Reply To: address as below
Reference: N6/2013/2219/FP
and N6/2014/1307/FP
Direct Tel: 01707 357512
Fax: 01707 357255
Email: s.smith@welhat.gov.uk

**Amendments to existing and proposed window and door openings
7 Densley Close, Welwyn Garden City**

I refer to your application seeking permission for a non material amendment in connection with the above.

FIRST FLOOR PLAN

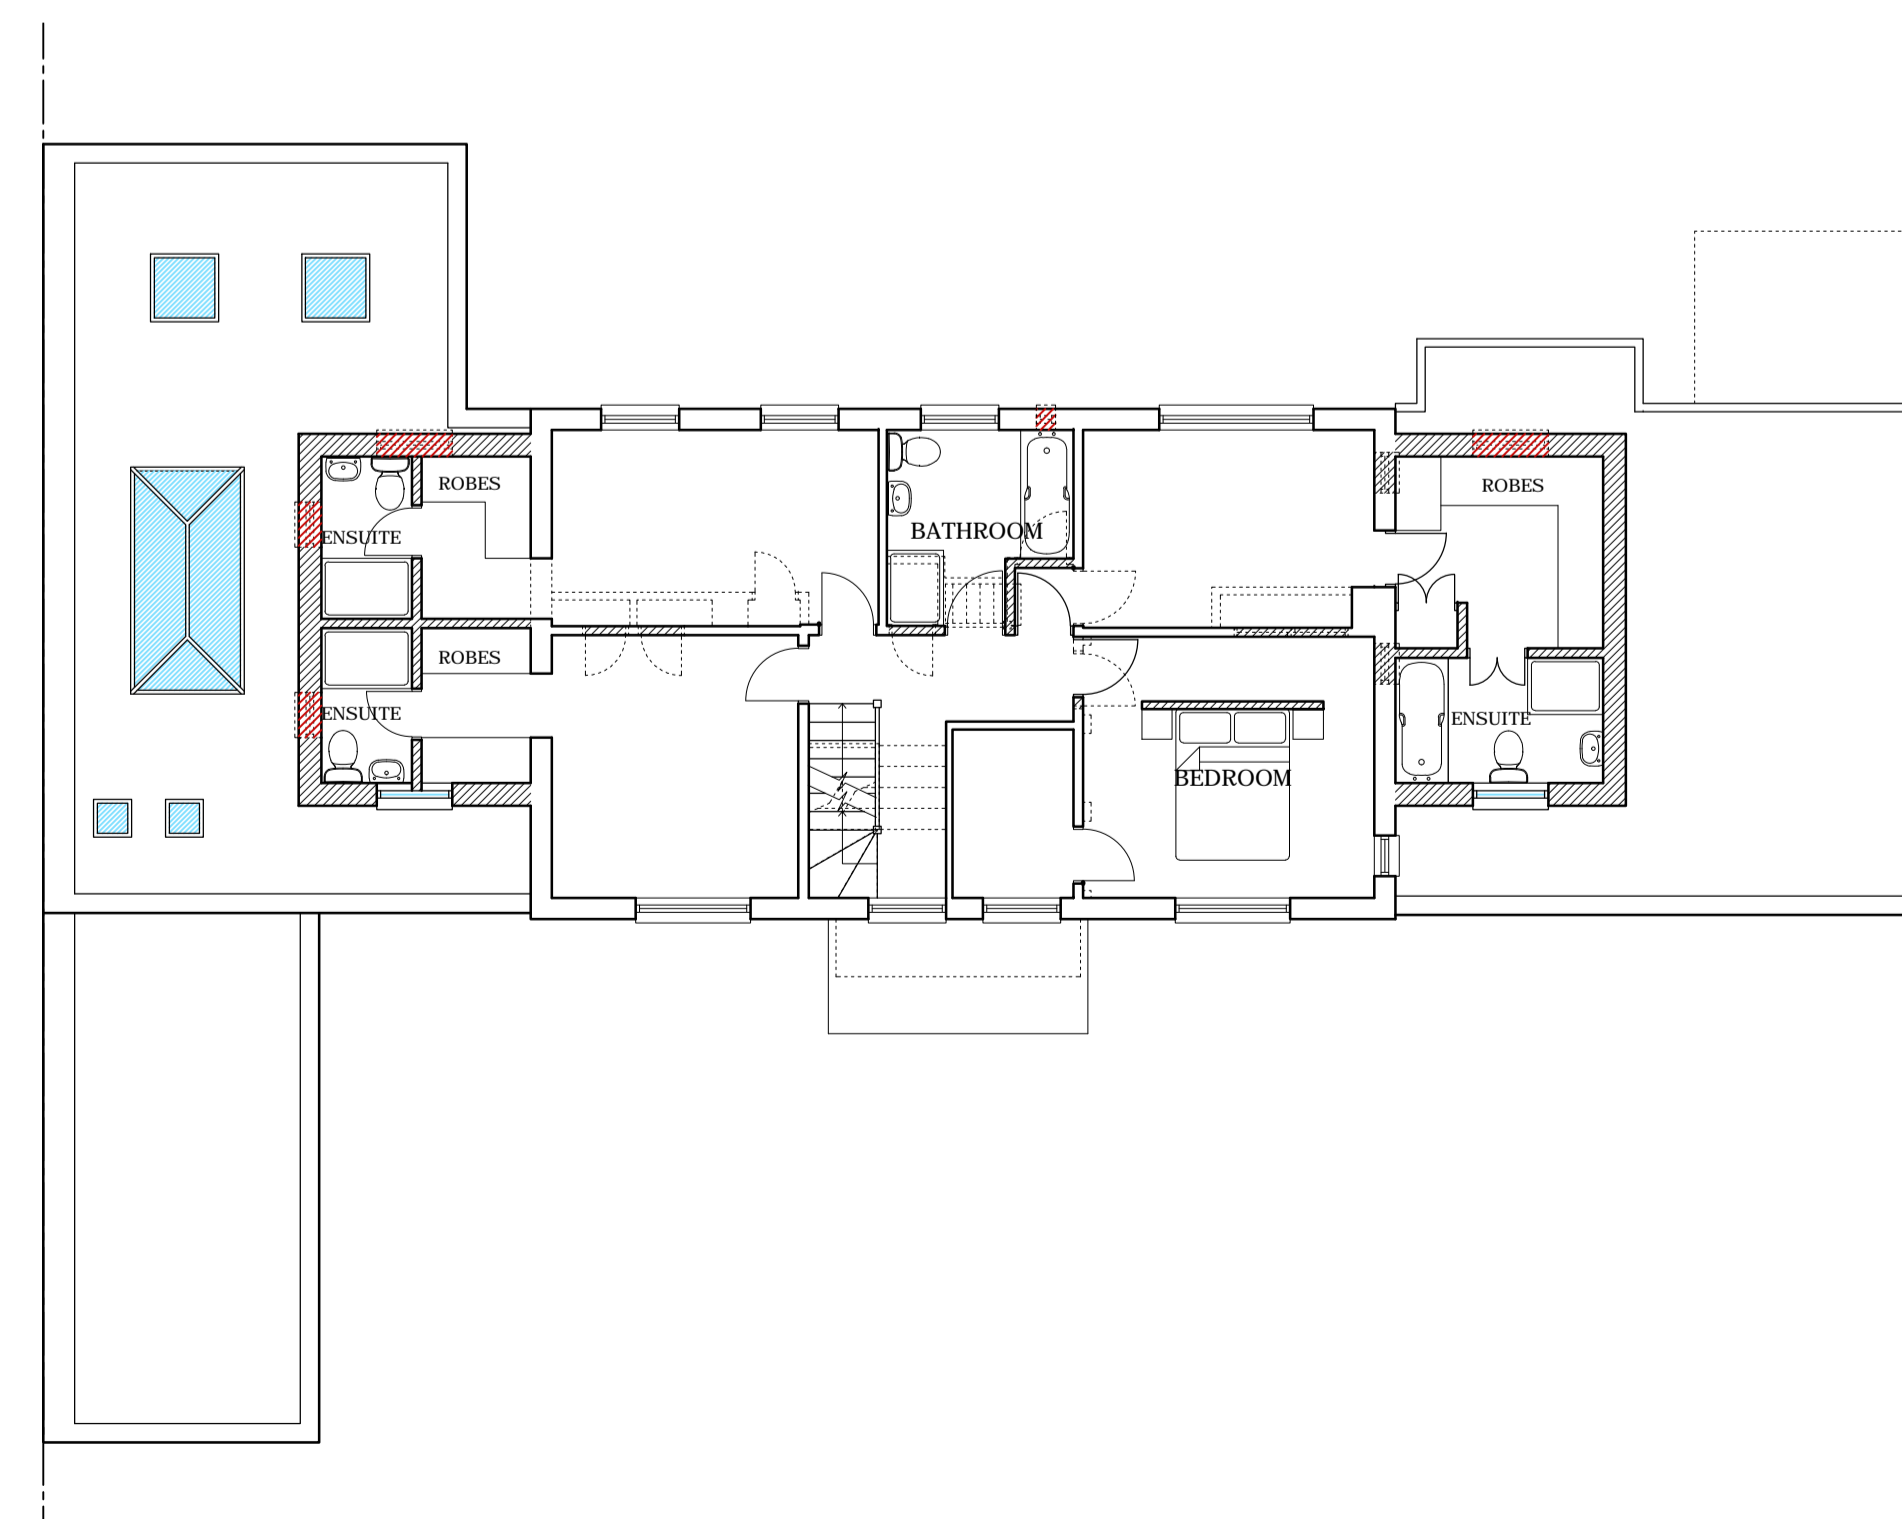
The amendments shown on the submitted drawings are considered to be a non-material amendment to the original planning permissions as the proposed changes are located within the existing property and the changes to the appearance of the property are not in my opinion significant and would not be materially different to that originally approved and the changes would not contravene any Planning Policy. Additionally the interests of any third party or body who participated in or were informed of the original decision would not be disadvantaged in anyway.

Accordingly, the Council considers the proposed amendments to be non material and acceptable. Those approved changes are to the fenestration only as listed above and for no other aspects of the approved scheme. The approved amendments are shown on Drawing No. 3018-P03 Rev C received and dated 12 May 2016.
